RE: **Denny's Restaurant – Broadstone Town Center**
Lot 4, Broadstone Towne Center
Grading & Drainage Plan for Building Permit and SO-19

File: **L15-D055C**

GRADING AND DRAINAGE PLAN

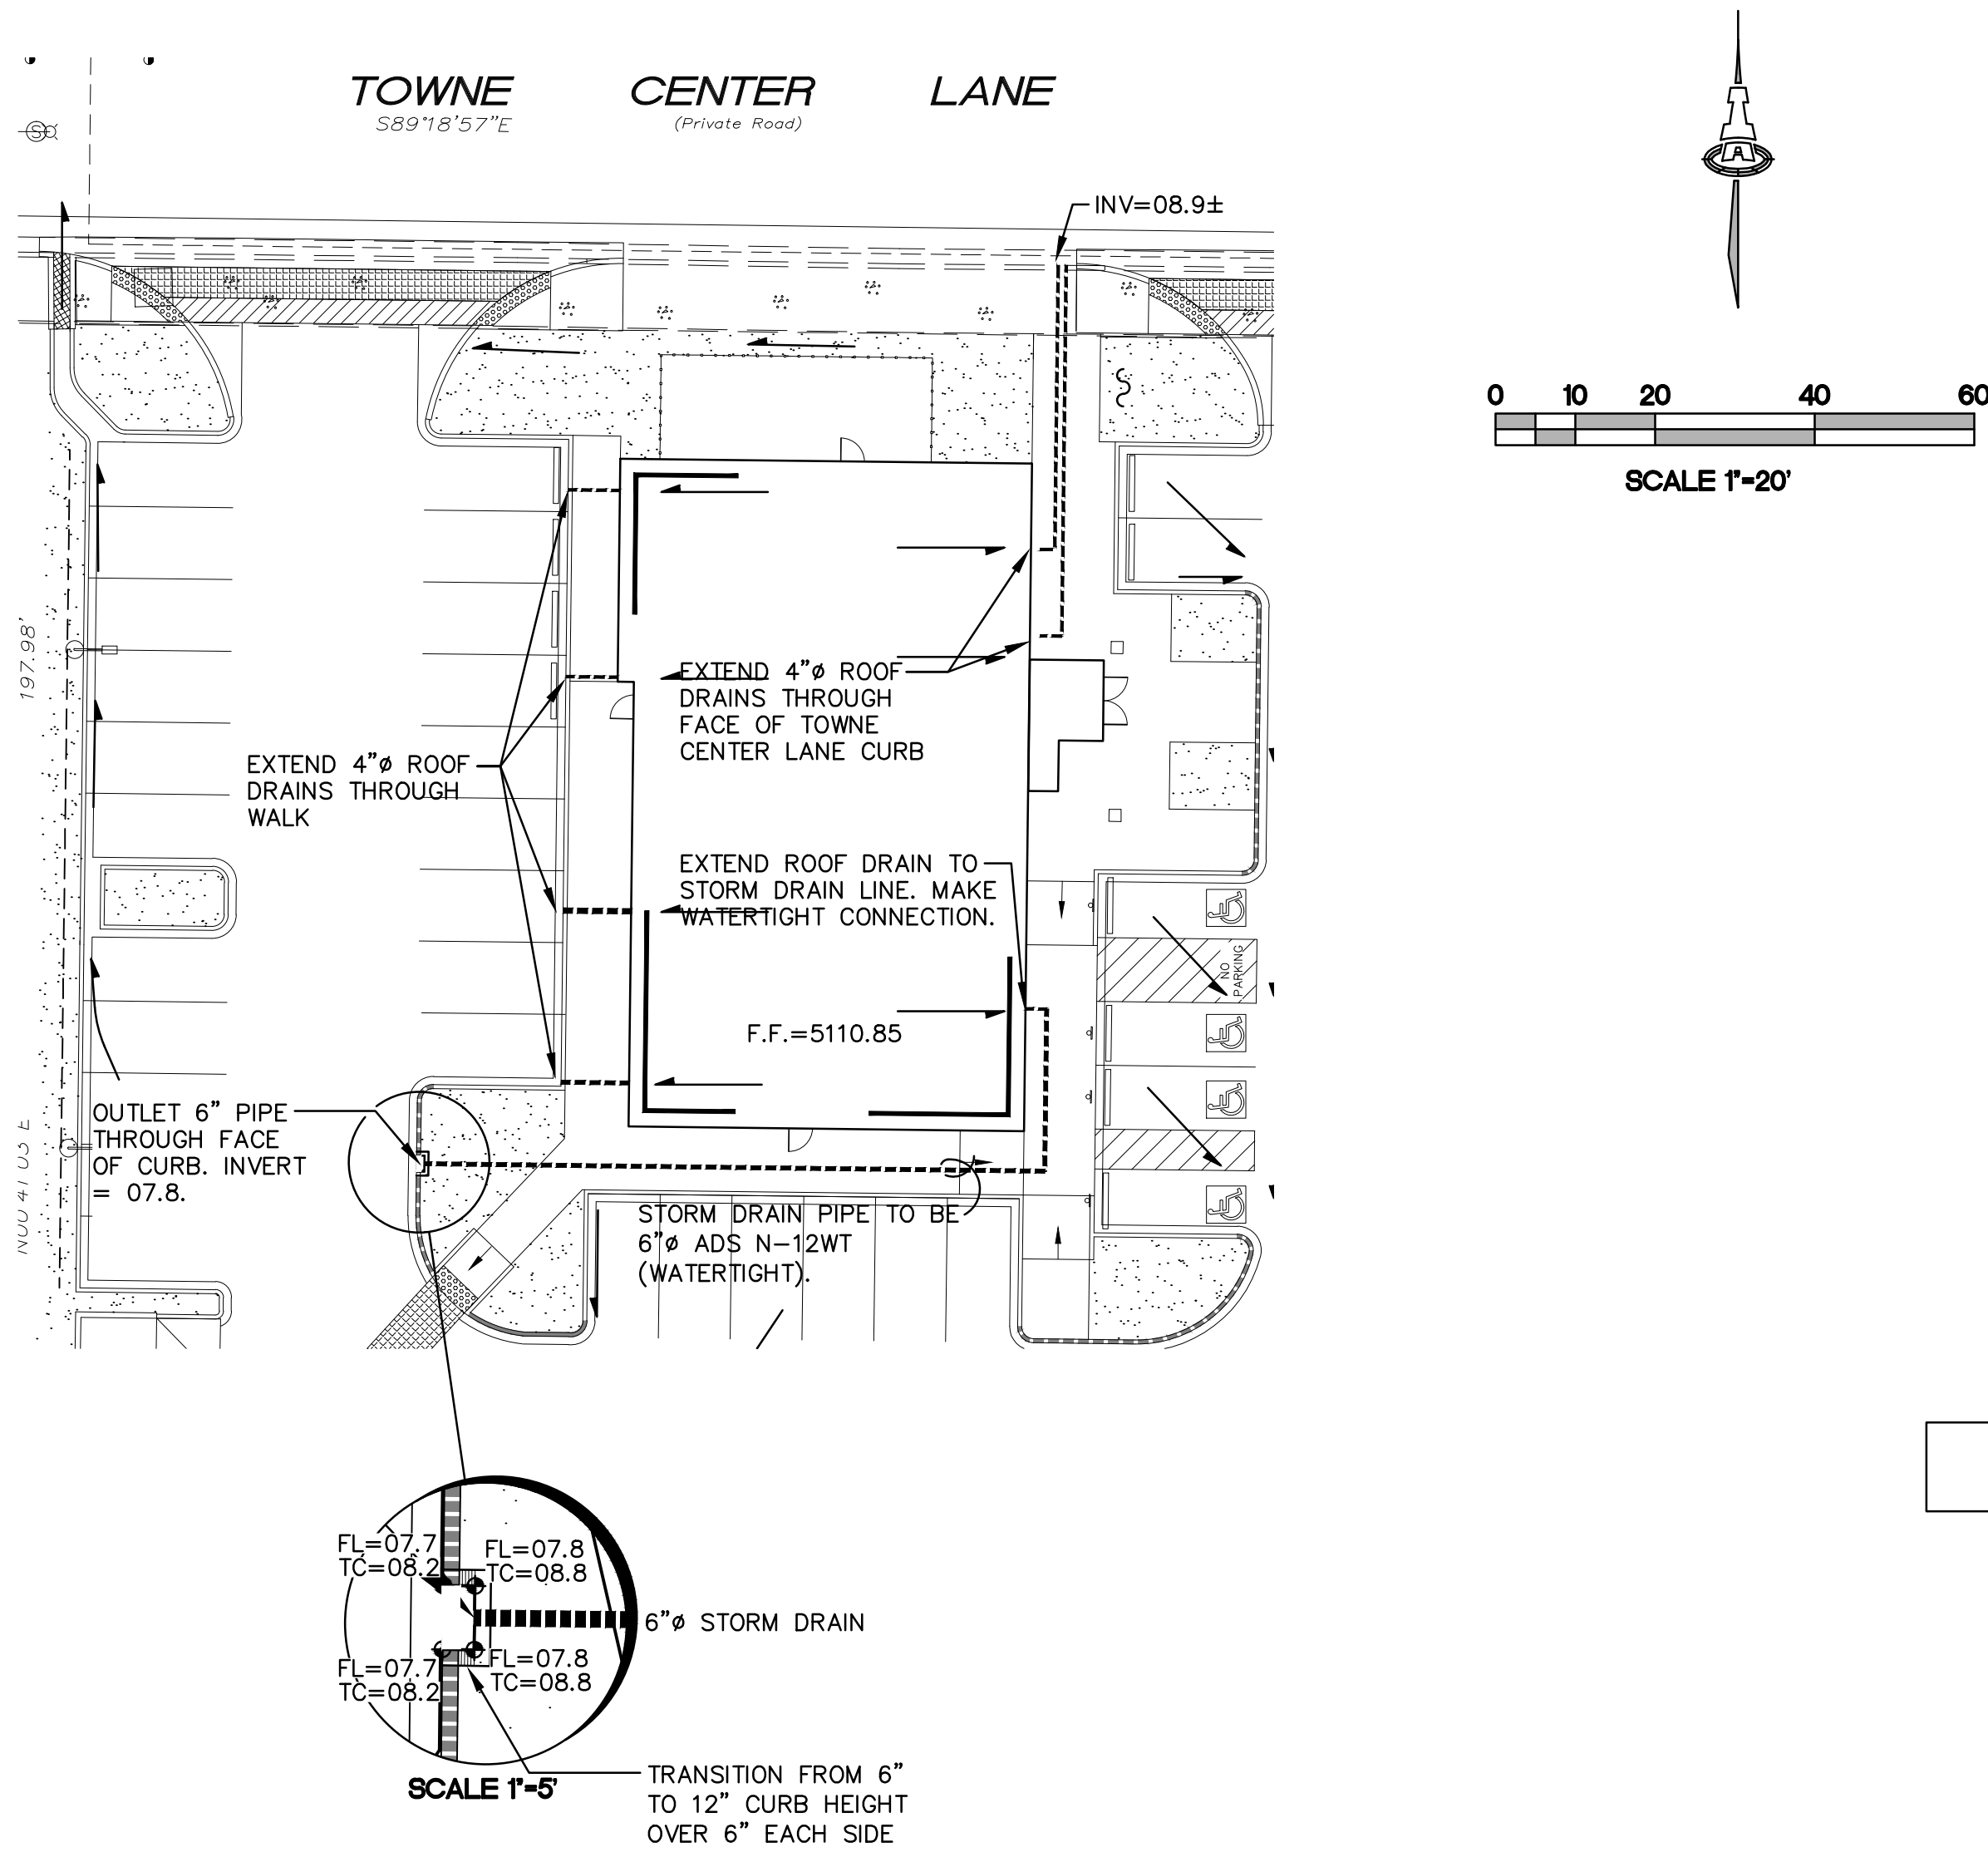
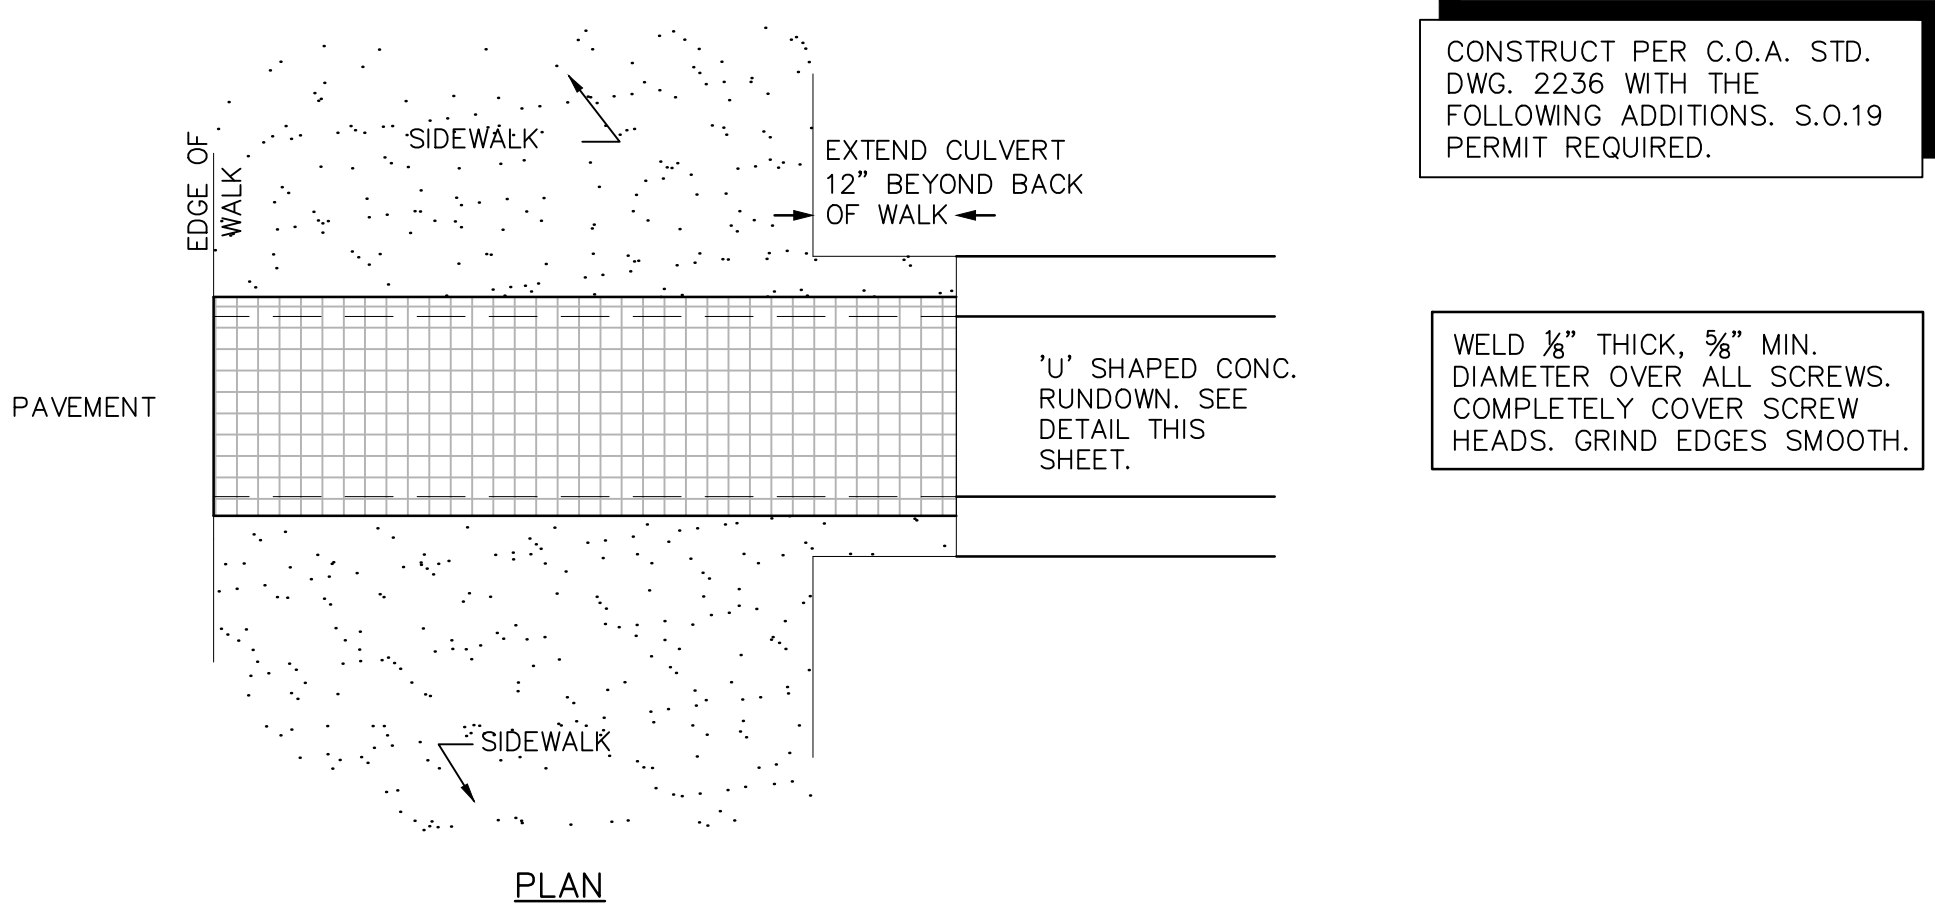
1. Please add the standard "SO-19" notes and approval block for the Roof Drains through the curb and the Sidewalk Culvert.
2. The SO-19 details on sheet CG-501 should make reference to the respective, City Standard Drawings 2235 and 2236.
3. Please add a spot elevation at the center of each of the depressed landscaped areas, to ensure harvesting occurs. Can you add note 11 and a spot elevation near the west end of the landscaping, just east of the curb cut on the east side of the west entrance?
4. In the interest of water harvesting, please try to route the west curb flows through the landscape islands, rather than past them in concrete channels.

- ✓ 1. SO-19 approval block added. Keyed notes revised to include SO-19 reference.
- ✓ 2. Details on Sheet CG-501 revised to include reference to COA Std. Dwgs.
- ✓ 3. Spot elevation added at center of each depressed landscape area, legend updated to include new spot type.
- ✓ 4. The small parking island along the west curb will harvest rainwater which falls on it. The main concrete channel to the sidewalk culvert which passes flow to Towne Center Lane has been kept due to the extensive underground utilities in this area.
